Date: 23-May-2025  
Our Ref: 2025/90833

**TOWN AND COUNTRY PLANNING ACT 1990  
TOWN AND COUNTRY PLANNING (GENERAL PERMITTED DEVELOPMENT)  
(ENGLAND) ORDER 2015 (as amended), SCHEDULE 2, PART 3, PART MA  
NOTIFICATION OF PROPOSED CHANGE OF USE CLASS MA – COMMERCIAL,  
BUSINESS AND SERVICE USES TO DWELLINGHOUSES  
APPLICATION NUMBER: 2025/90833  
AT: 37, Bradford Road/ 2 & 4 King Street, Cleckheaton, BD19 3JN**

**Prior approval of a proposed change of use of a building from commercial, business and service uses to dwellinghouses**

PROPOSED PLANS Scale 1.100

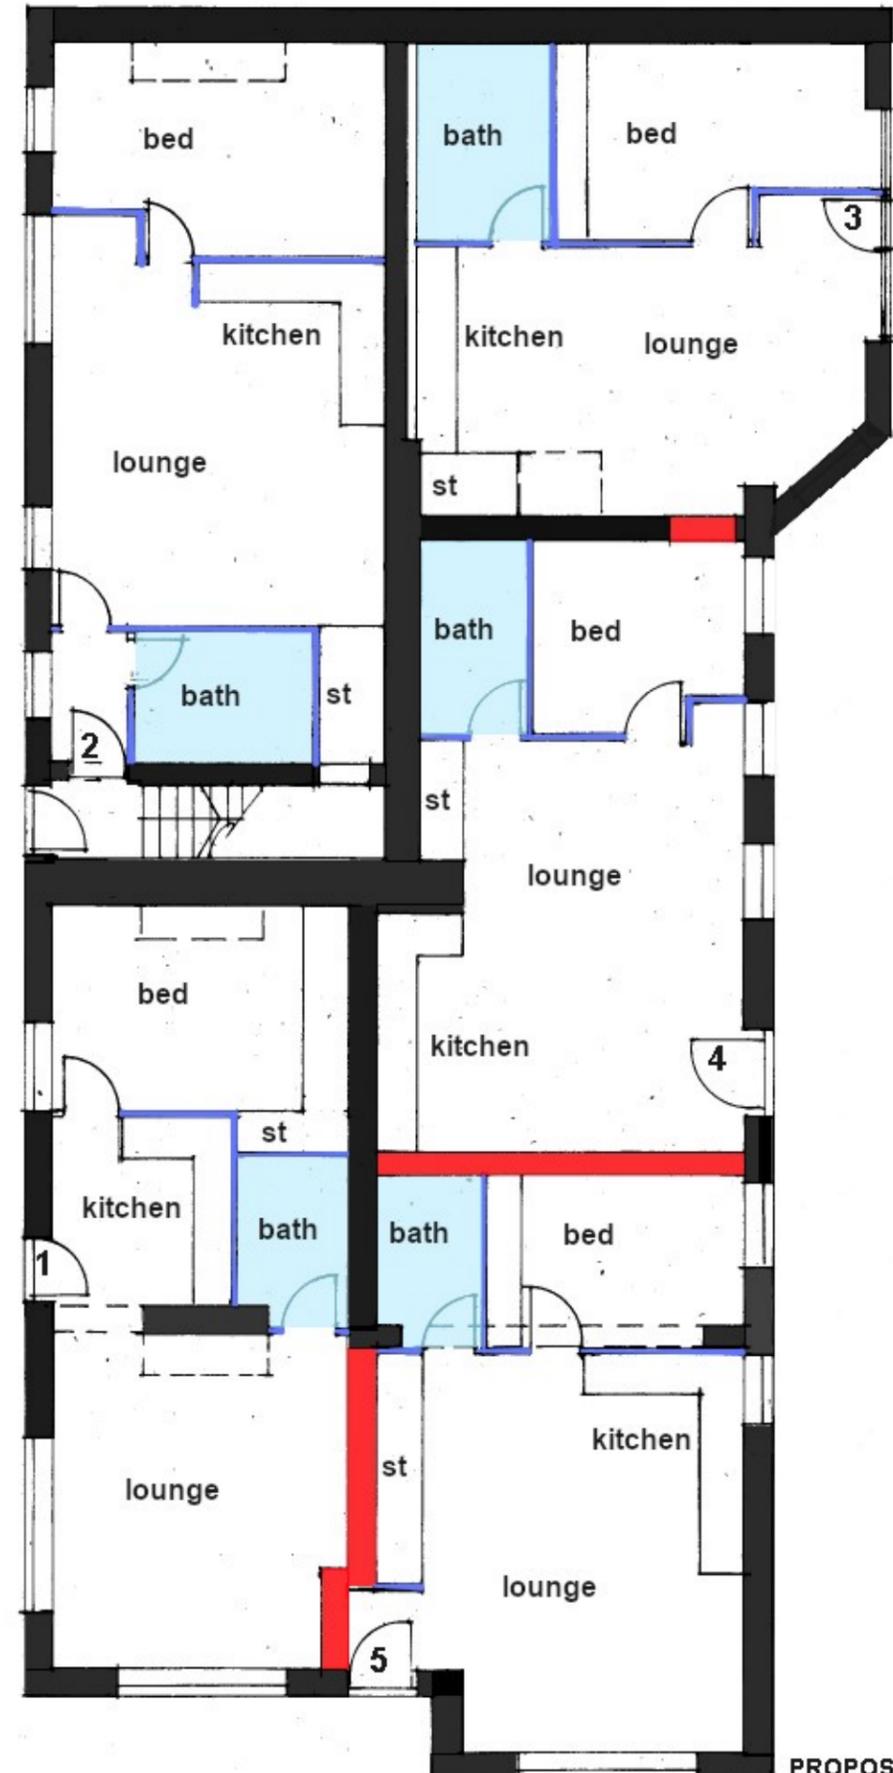
1. The development fails to demonstrate that all habitable rooms within the proposed dwellings would receive adequate natural light, as required under Paragraph MA.2.2(f) of Part 3, Schedule 2 of the Town and Country Planning (General Permitted Development) (England) Order 2015 (as amended). Habitable rooms on the south elevation would face, in close proximity, to a three storey building. The applicant has not demonstrated that both direct and ambient light would not be reduced to an unacceptable level.
